# Construction Drawings (PlansProfiles)\_v1.pdf Markup Summary

## 8-29-2022

Cursory comments

P:\CO\2024\Bent Grass Meadows\Drawings\CADD\CONSTRUCTION\CONSTRUCTION\10-LEMONGRASS DR IMPROVEMENT PLAN.dwg, 3/22/2024

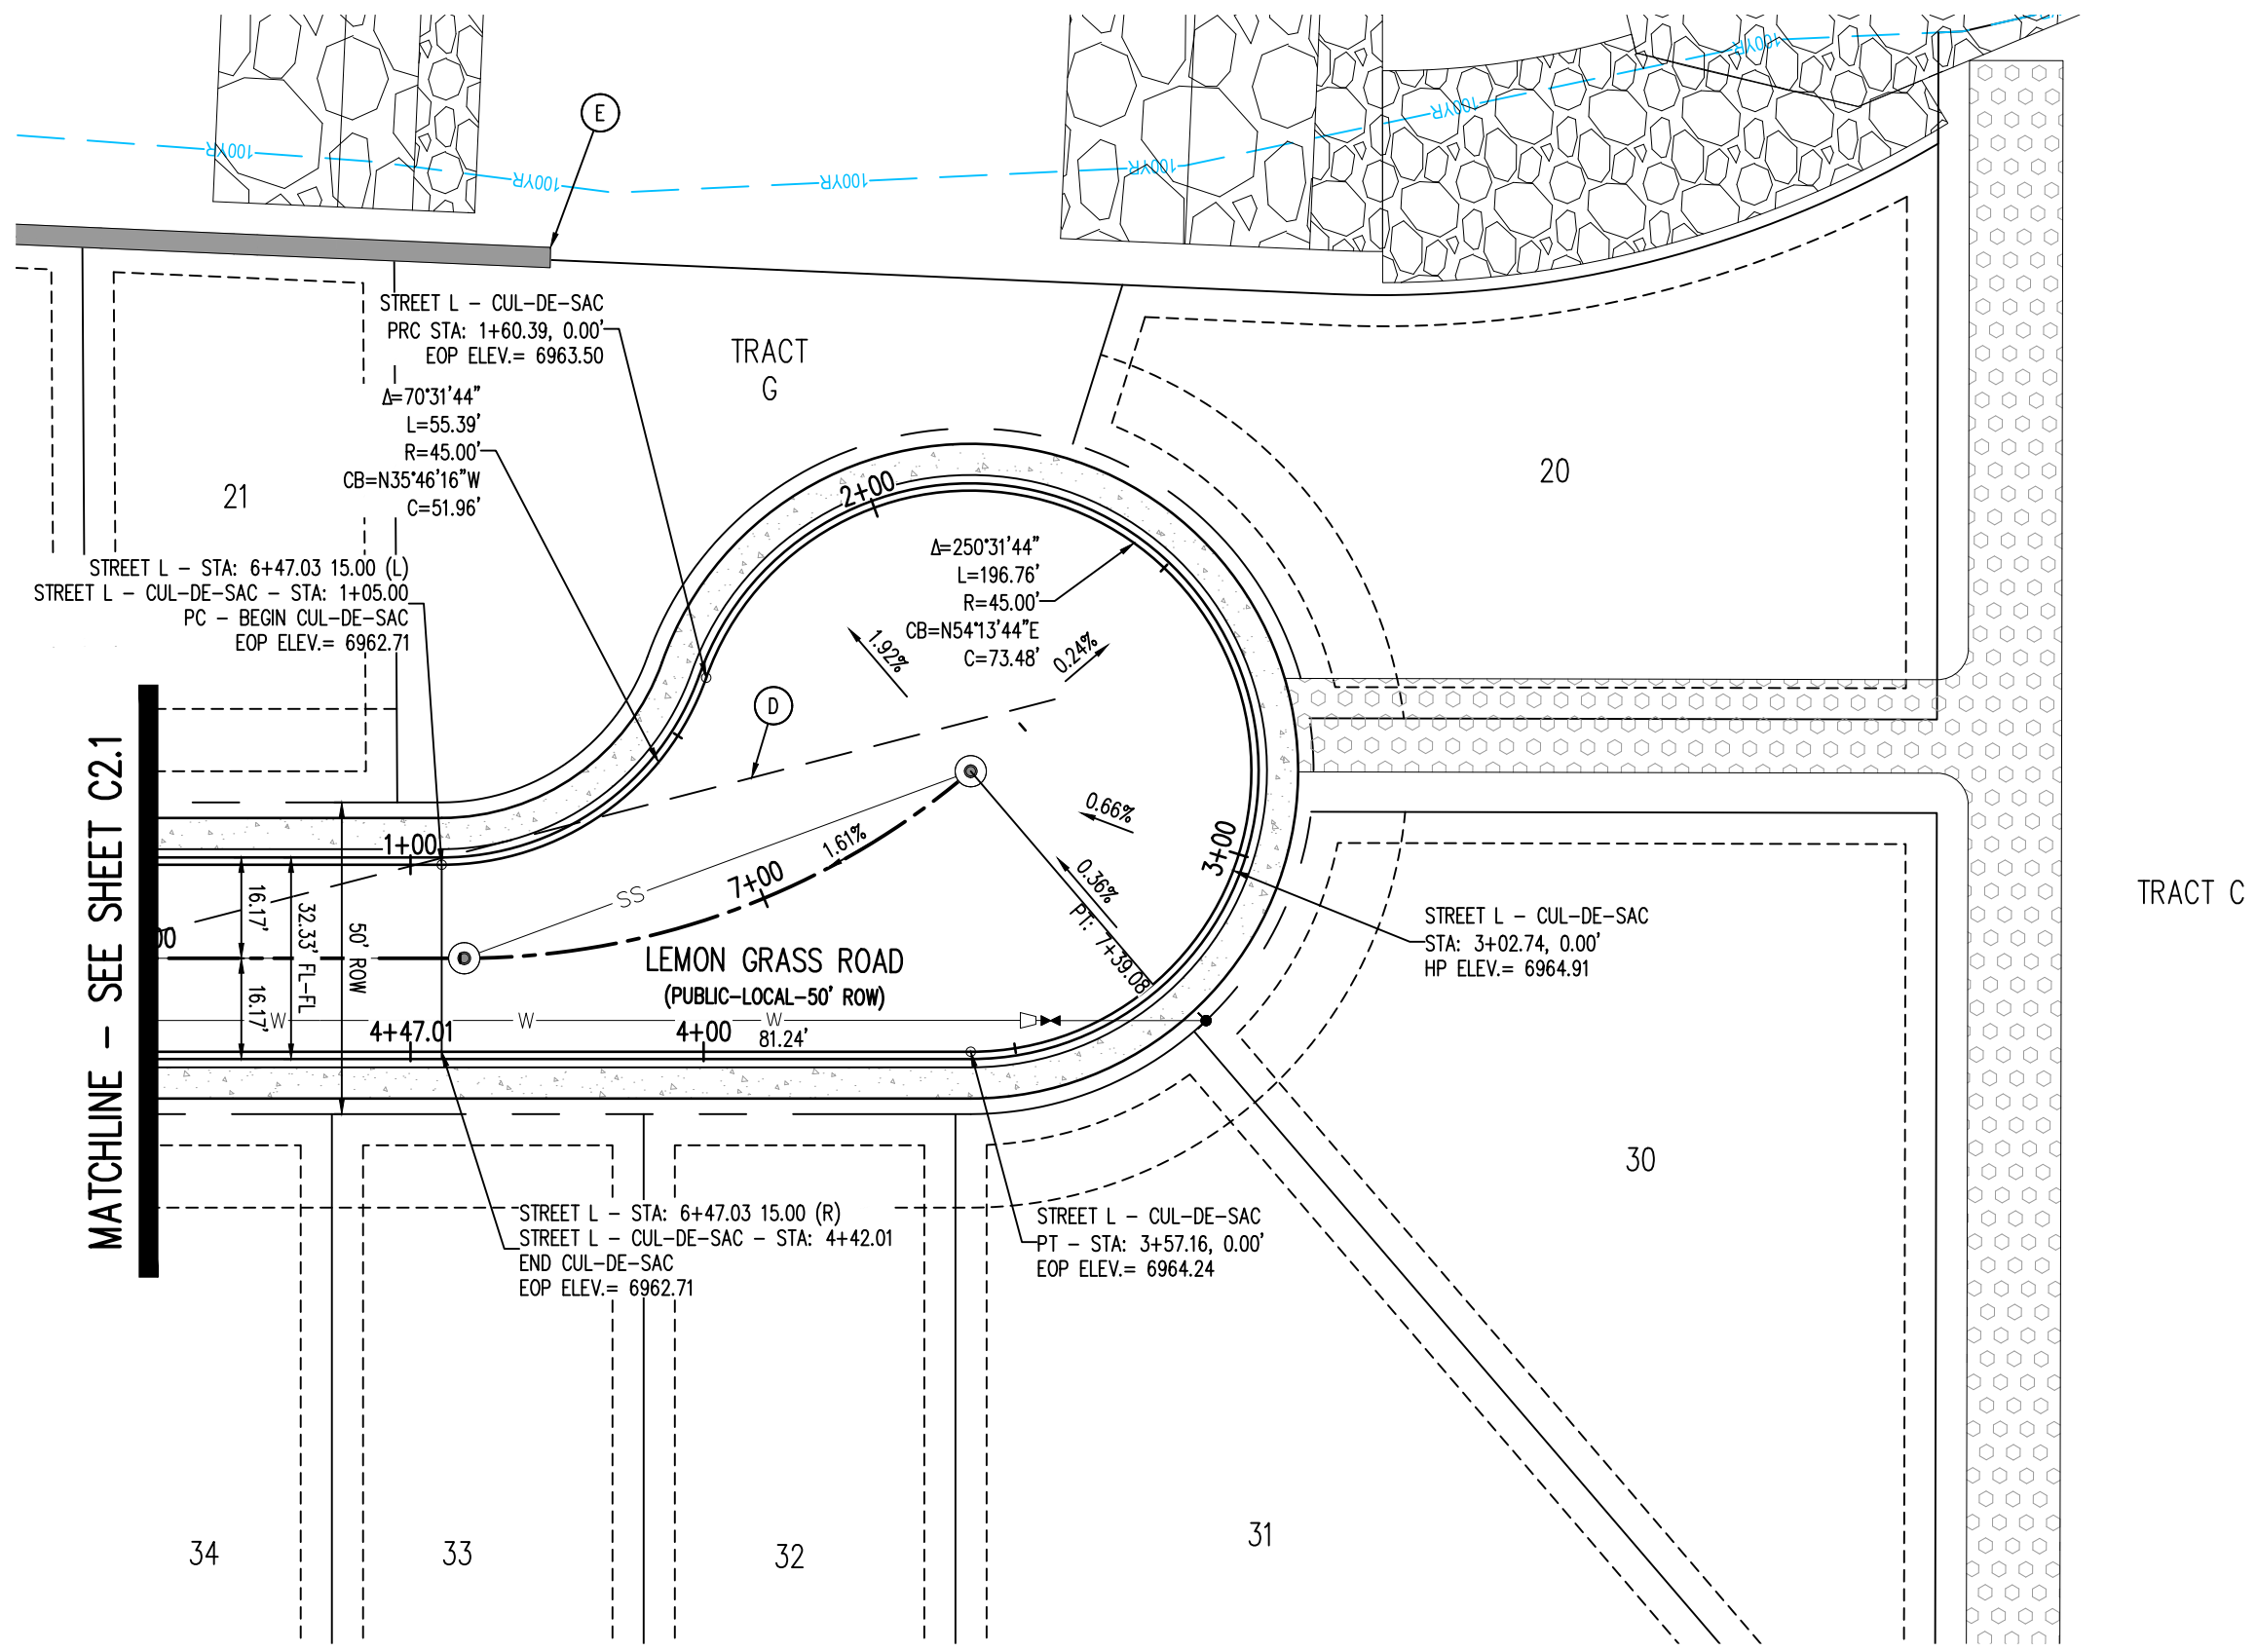
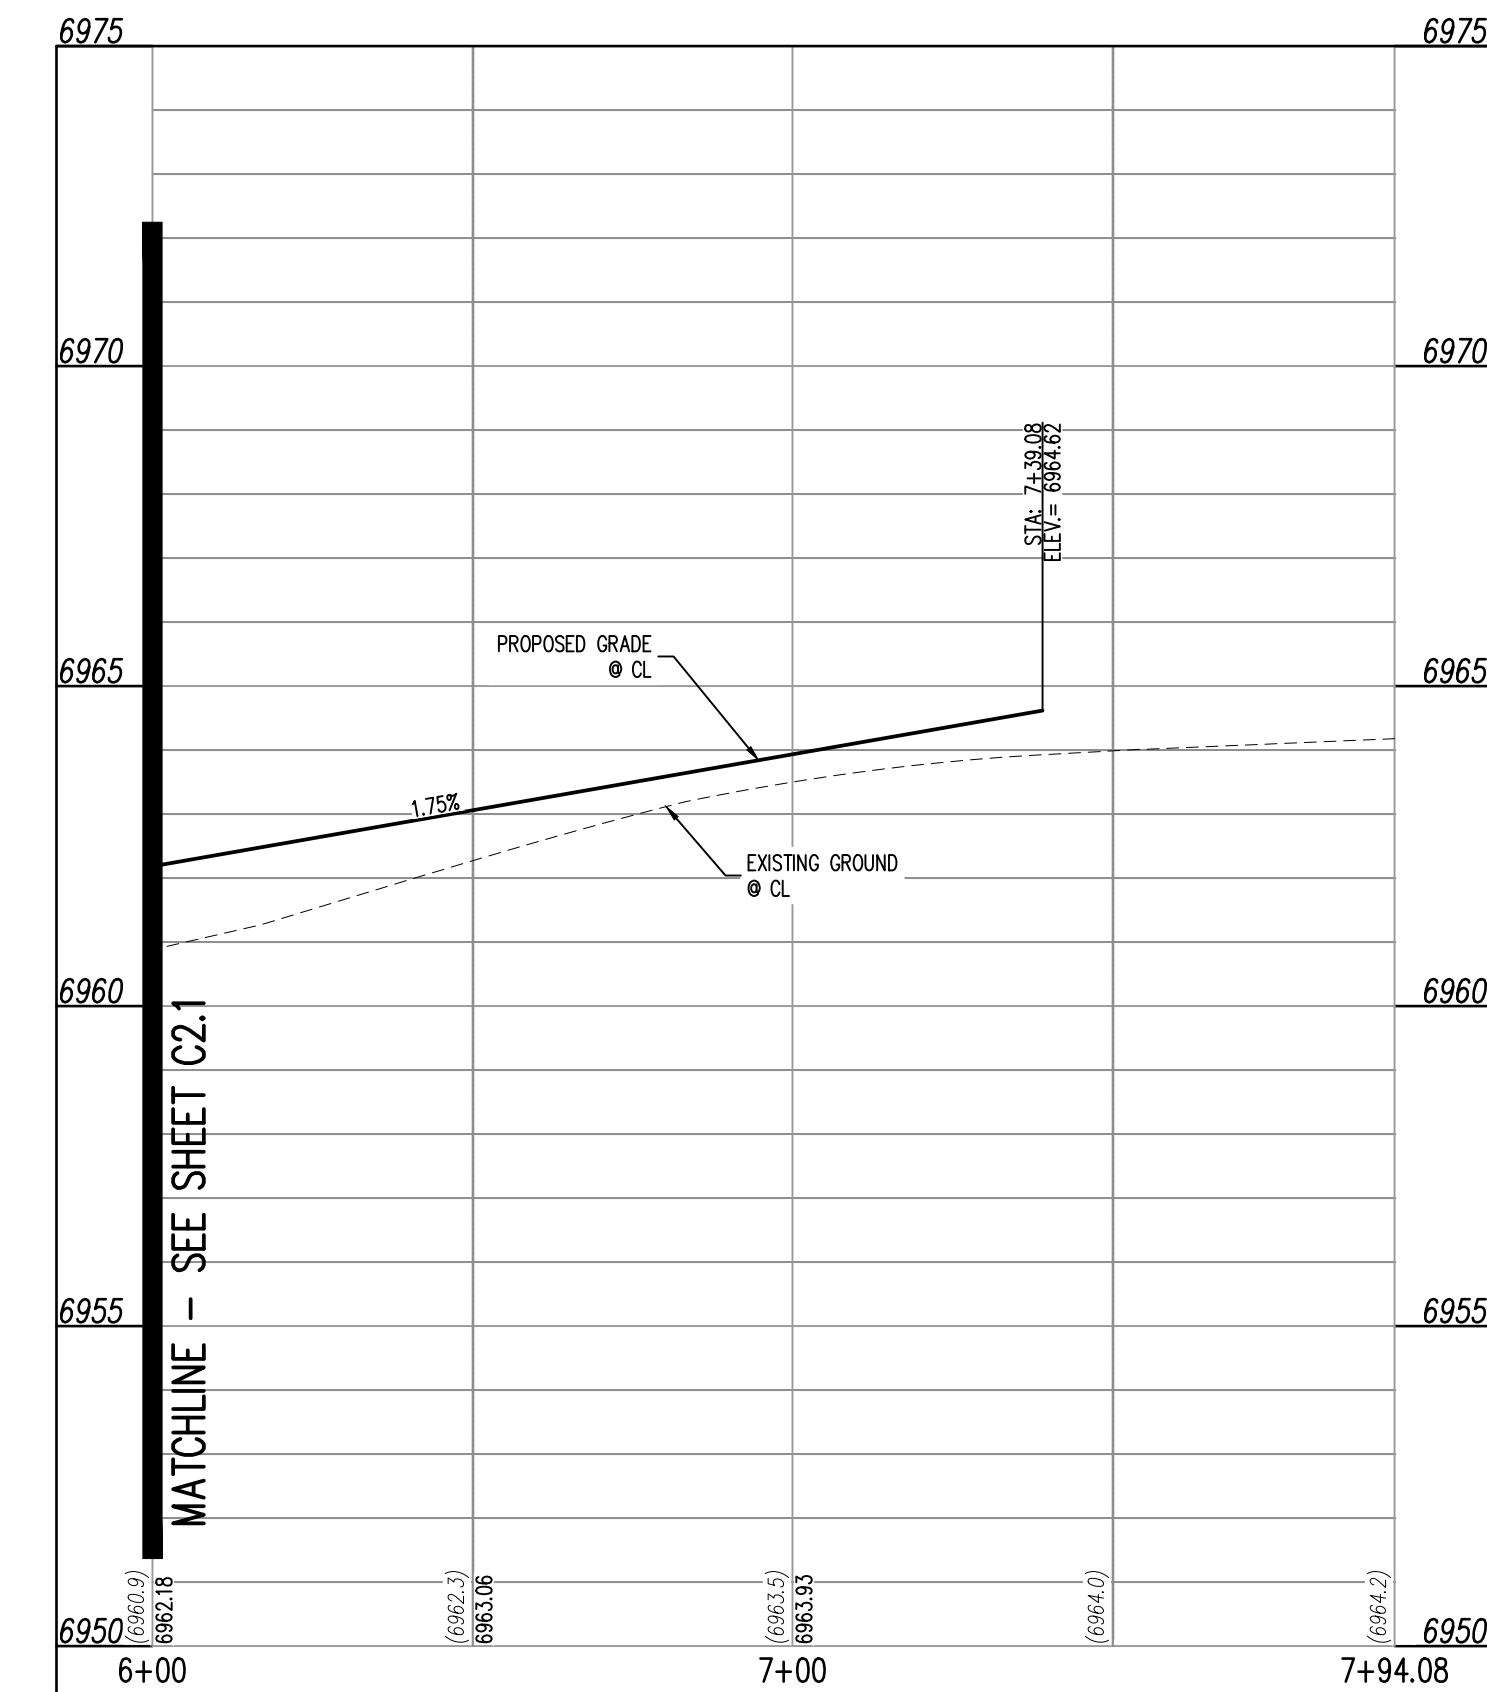
There appears to be a 3% grade break here - revise tangent to VC

Reduce grade break to <1% and space away from the vertical curve or remove and adjust the vertical curve

**Subject:** Callout  
**Page Label:** [5] 5 LEMON GRASS RD IMPROVEMENT PLAN Provide vertical curves or reduce the grade break to <1%  
**Author:** dsdrice  
**Date:** 8/19/2022 2:03:16 PM  
**Status:**  
**Color:** ■  
**Layer:**  
**Space:**

**Subject:** Callout  
**Page Label:** [5] 5 LEMON GRASS RD IMPROVEMENT PLAN Does not meet minimum K values  
**Author:** dsdrice  
**Date:** 8/19/2022 2:05:14 PM  
**Status:**  
**Color:** ■  
**Layer:**  
**Space:**

**Subject:** Callout  
**Page Label:** [5] 5 LEMON GRASS RD IMPROVEMENT PLAN Provide sight visibility triangles  
**Author:** dsdrice  
**Date:** 8/19/2022 2:46:29 PM  
**Status:**  
**Color:** ■  
**Layer:**  
**Space:**

**Subject:** Callout  
**Page Label:** [5] 5 LEMON GRASS RD IMPROVEMENT PLAN Label as centerline-centerline intersections  
**Author:** dsdrice  
**Date:** 8/19/2022 2:48:41 PM  
**Status:**  
**Color:** ■  
**Layer:**  
**Space:**
